From: Planning
Sent: 13 April 2021 15:21
To: DC Support
Subject: FW: 21/00559/F - Carters Yard Main Street Sibford Gower OX15 5RW

Planning application:	21/00559/F
Location:	Carters Yard Main Street Sibford Gower OX15 5RW
Description:	Conversion of garage building and erection of a single storey extension, to form a granny annexe
Type:	Full Development
Case Officer:	Gemma Magnuson

Oxfordshire County Council, as the Local Highways Authority, hereby notify the District Planning Authority that they **object** to the granting of planning permission.

06D

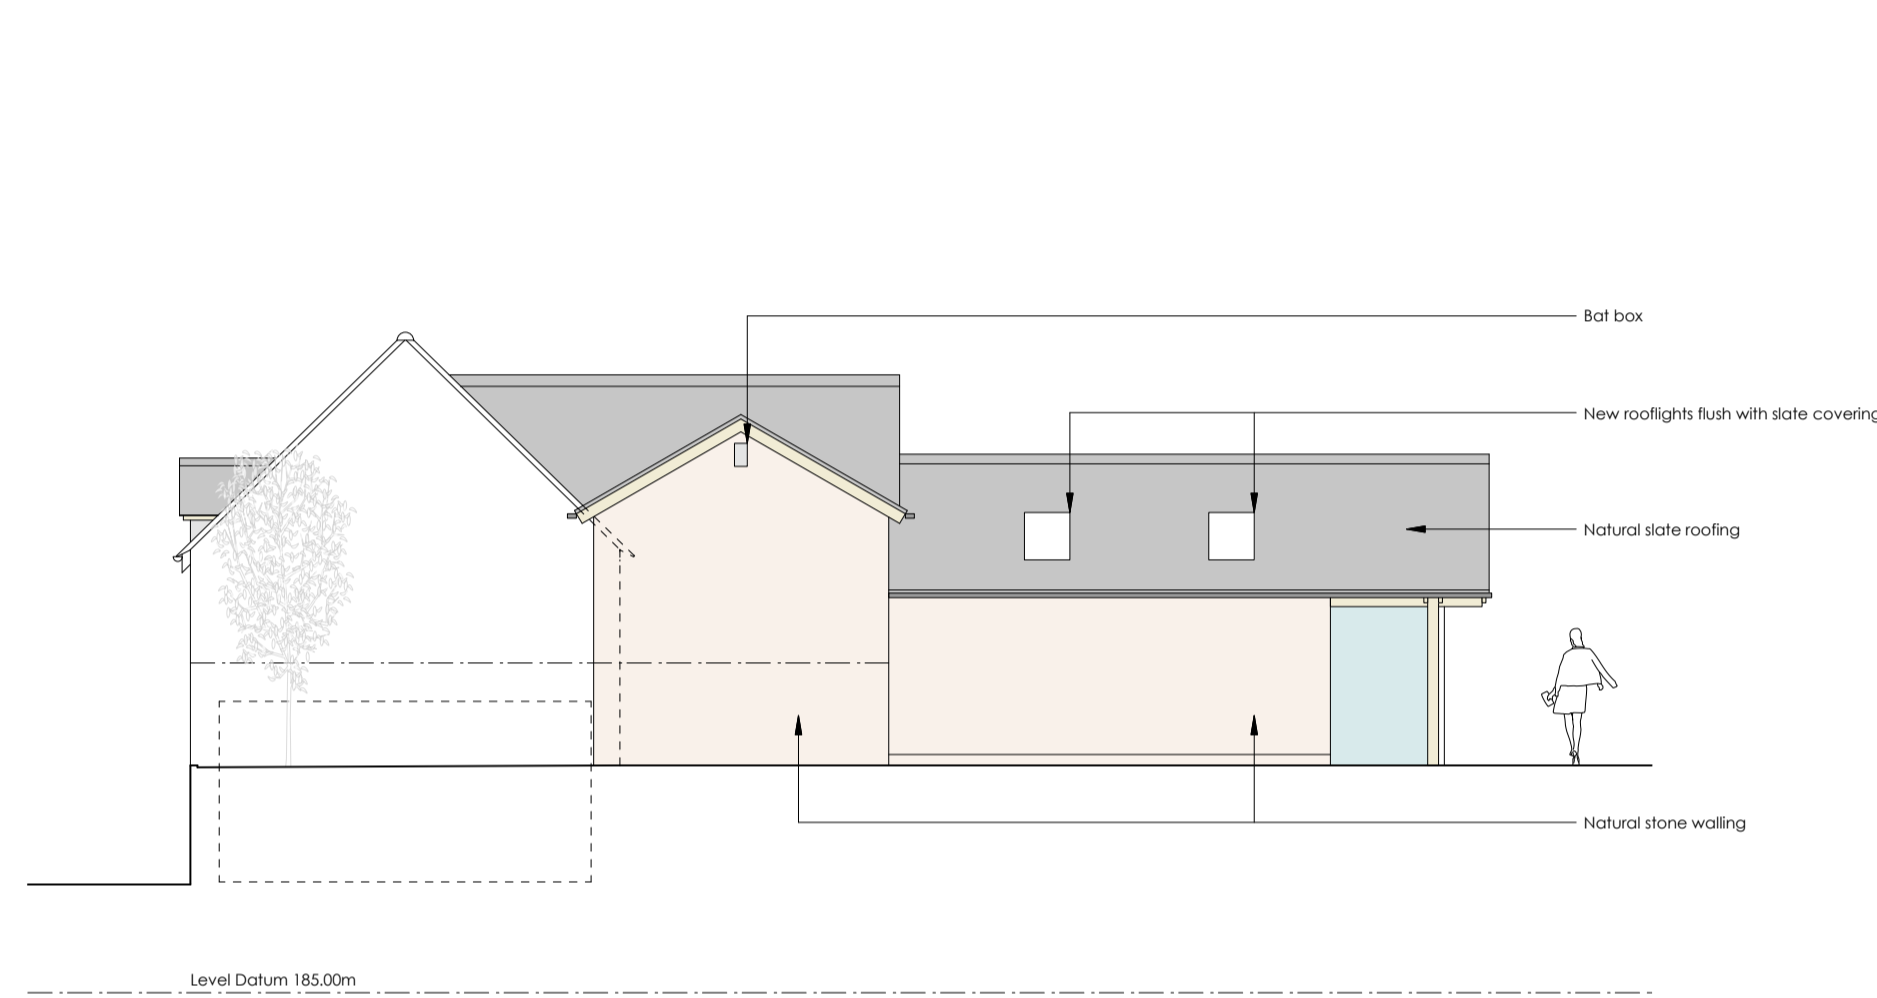
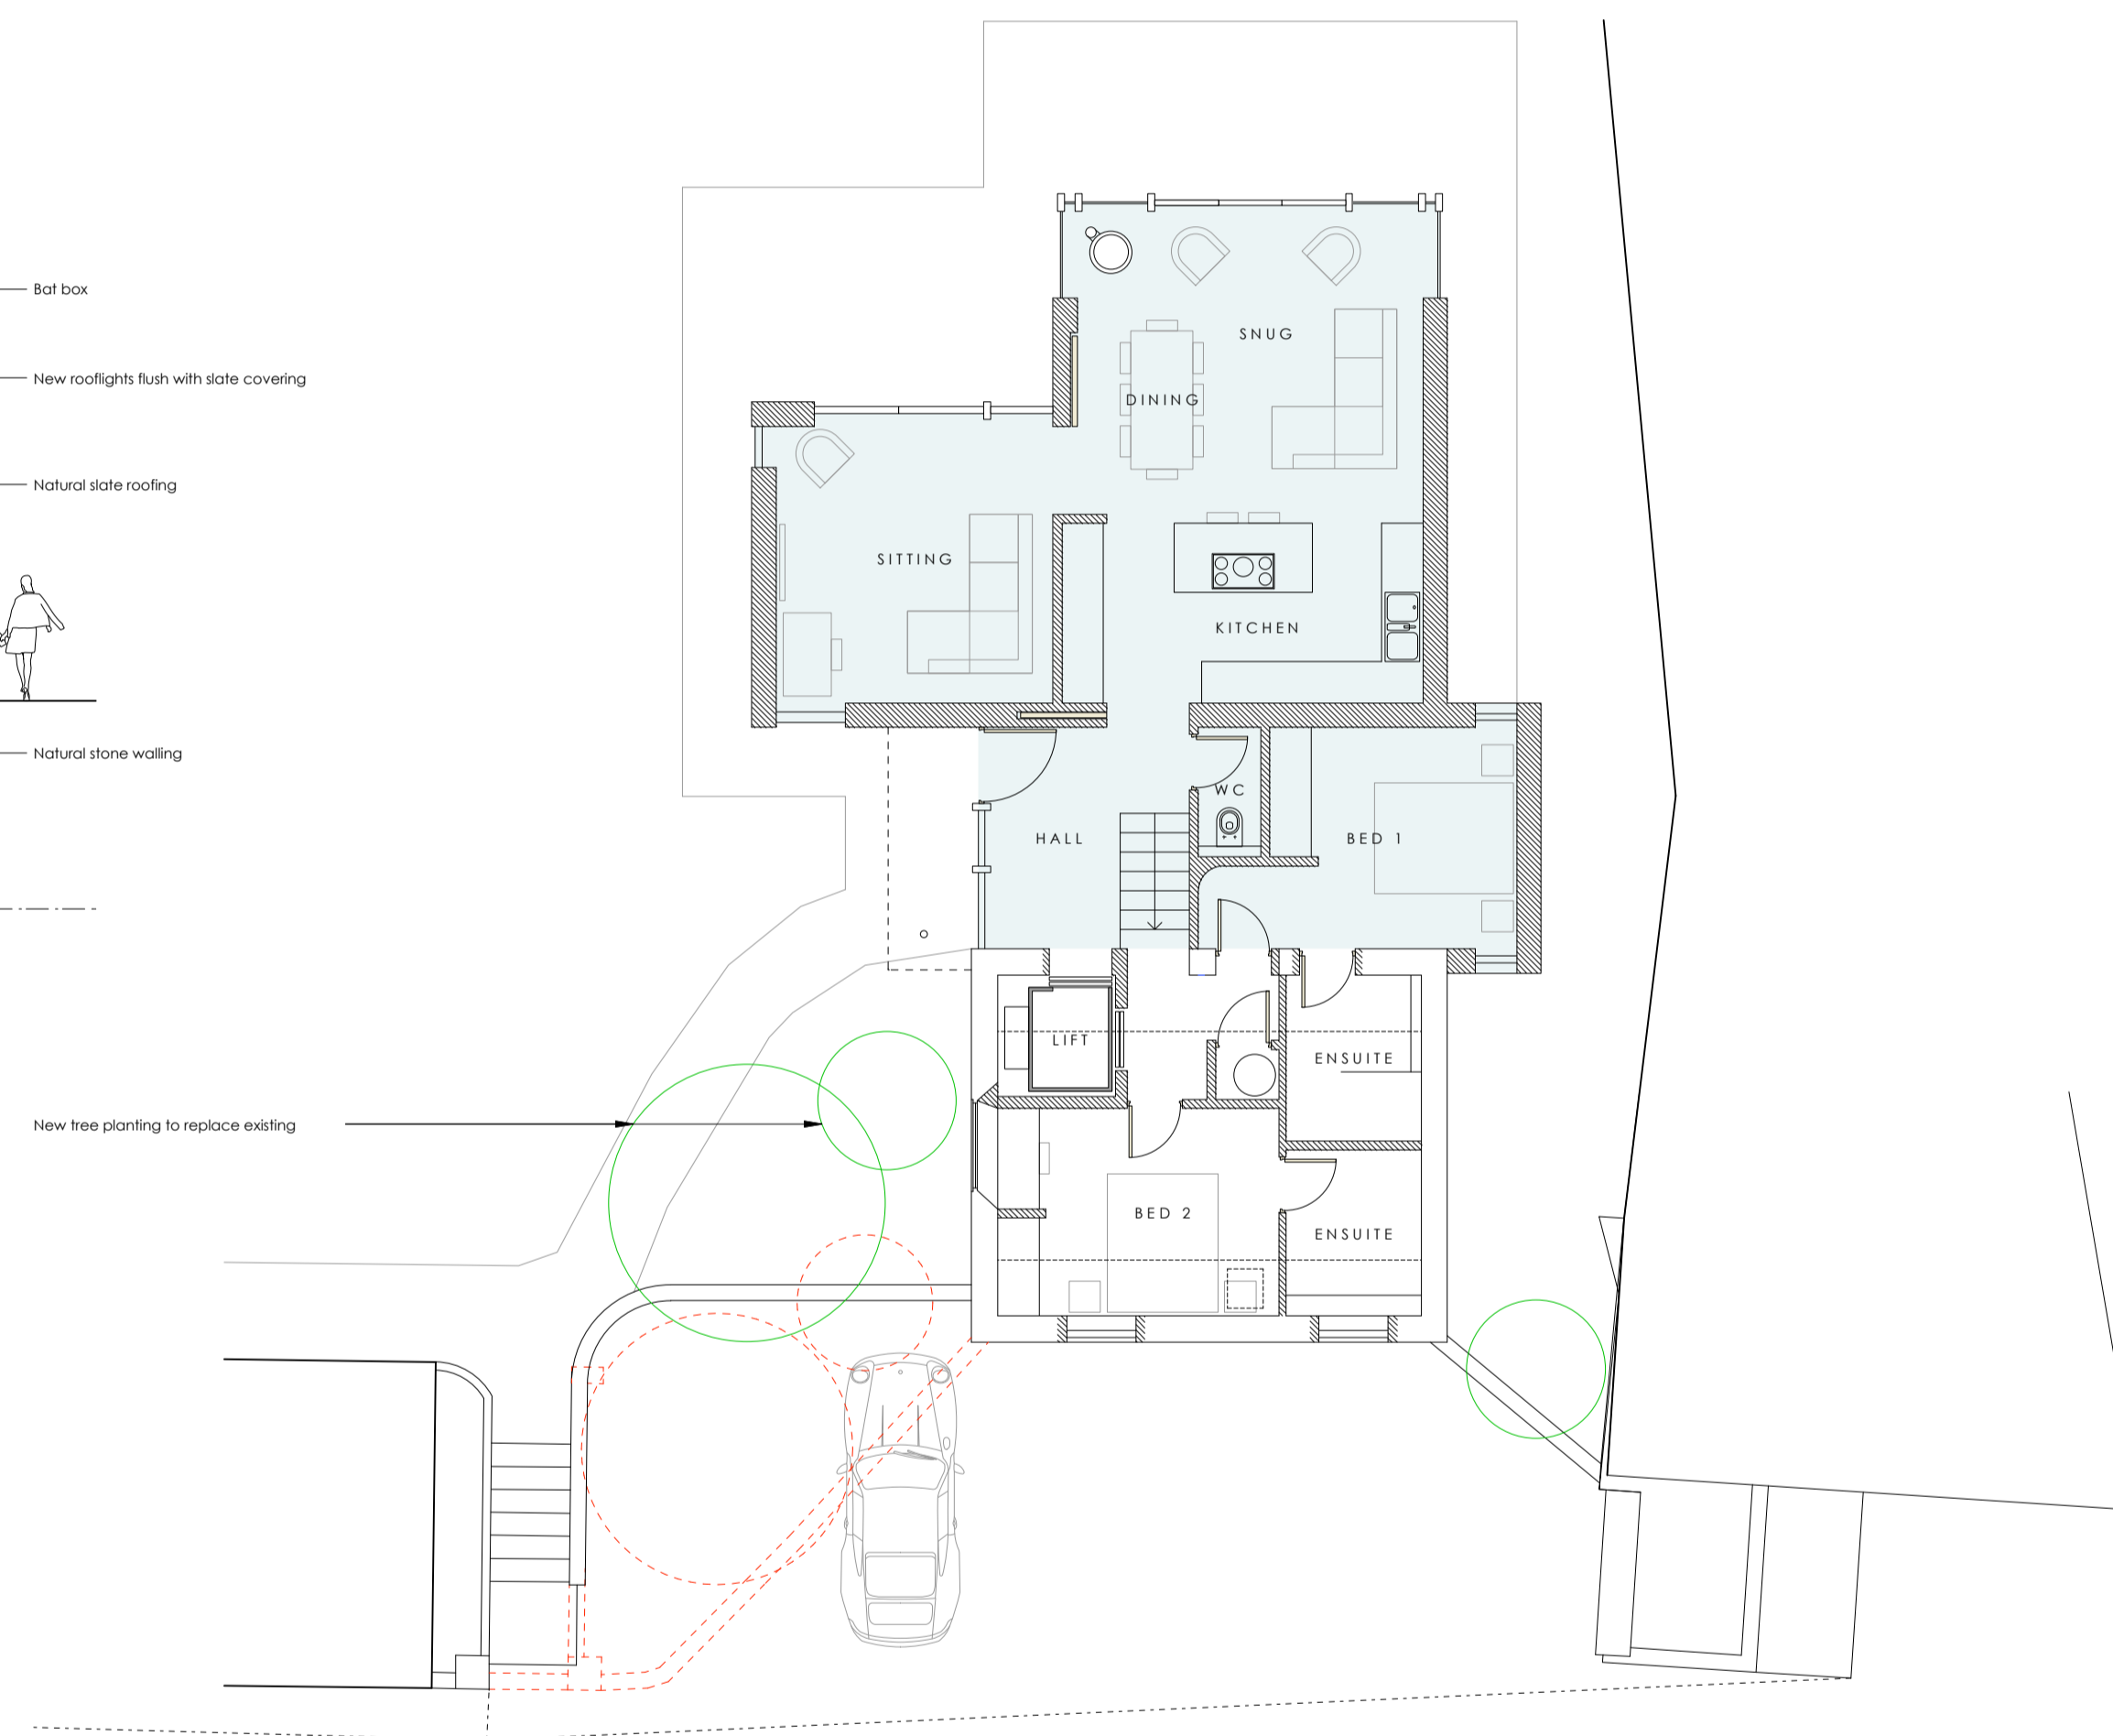
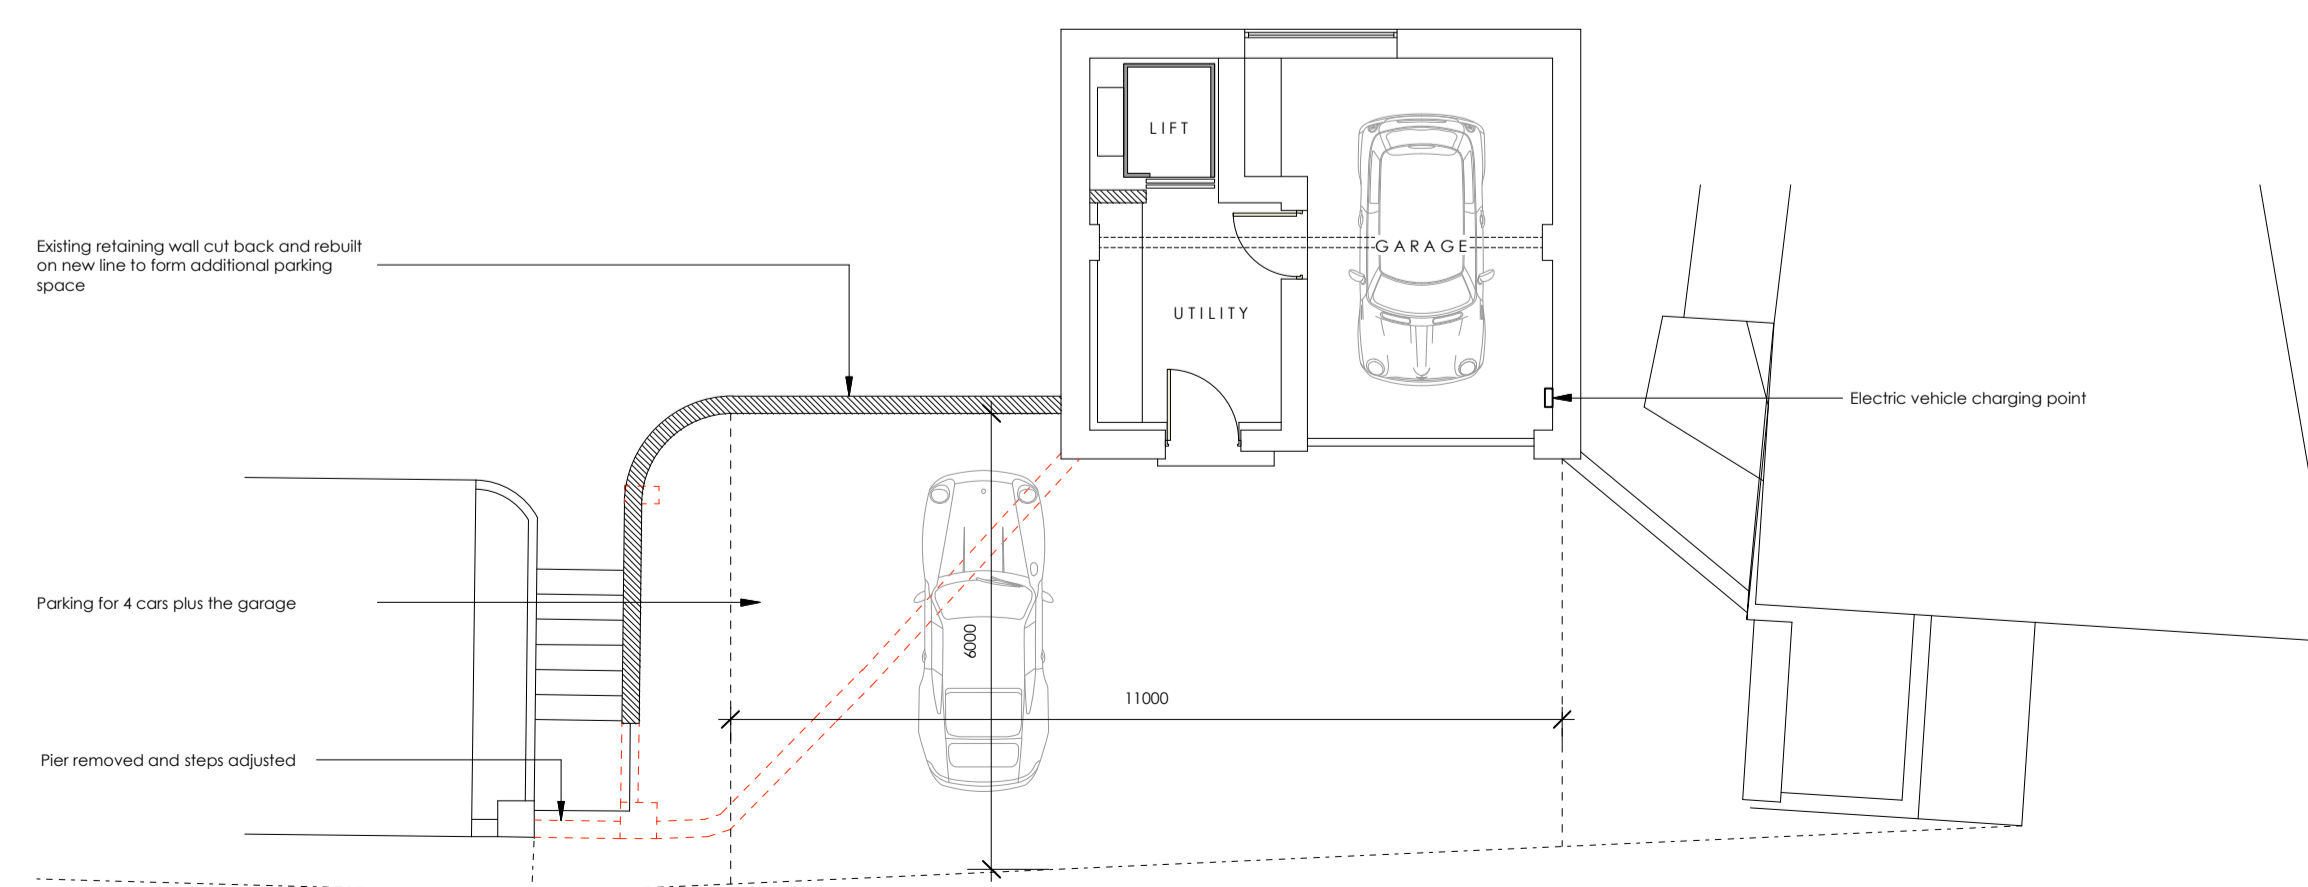
Drawings 06B (Proposals Sketch Scheme 2) and 07B (Proposals Sketch Site Plan 2) show a parking configuration of five parking spaces accessed off Colony Road. I will cover below why the parking provision of five vehicles here is inadequate. However, I wish to draw the applicant's attention to the two outer parking spaces as shown on the aforementioned drawings.

In order to egress from either of these spaces bounded by the sites boundary walls, this will require the bonnet of the vehicle to project out by at least a meter if not more, prior to the driver having any visibility at all of pedestrians, cyclists or other road users. This can be clearly seen from drawing 07B and the image of a car parked within this space.

Drawings 06B and 07B show parking for five vehicles accessed directly off Colony Road. Currently parking for only two vehicles perpendicular to the highway could be accommodated here, or one vehicle parallel, due to the tapering boundary walls.

I have measured the parking provision as shown on drawing 06B and I have included the space that still has a tapering boundary wall (southern-most space). A distance of 14.3m is possible, 1.8m more than is required for five unobstructed parking spaces.

However, parking in the southern-most space is not possible without overhanging out onto Colony Road, a situation that is unacceptable to the County Council. Therefore, this fifth space has been discounted. As a result, this leaves only 11.3m for the parking of five standard cars, 1.2m too short.

Should only four cars be proposed to park here instead, then a total minimum unobstructed width of 10m would be required. However, for reasons detailed above, the northern-most space here

cannot be counted due to the serious highway safety risk that is likely to occur if the space is occupied as designed.

As a result of the constrained nature of the parking area proposed, parking for only three standard cars will likely be possible within this area, if all three cars are parked perpendicular to the highway.

A sixth parking space has been proposed within the garage accessed from the lower ground floor. However, this space has not been counted as a parking space, as its dimensions fall below the acceptable minimum levels.
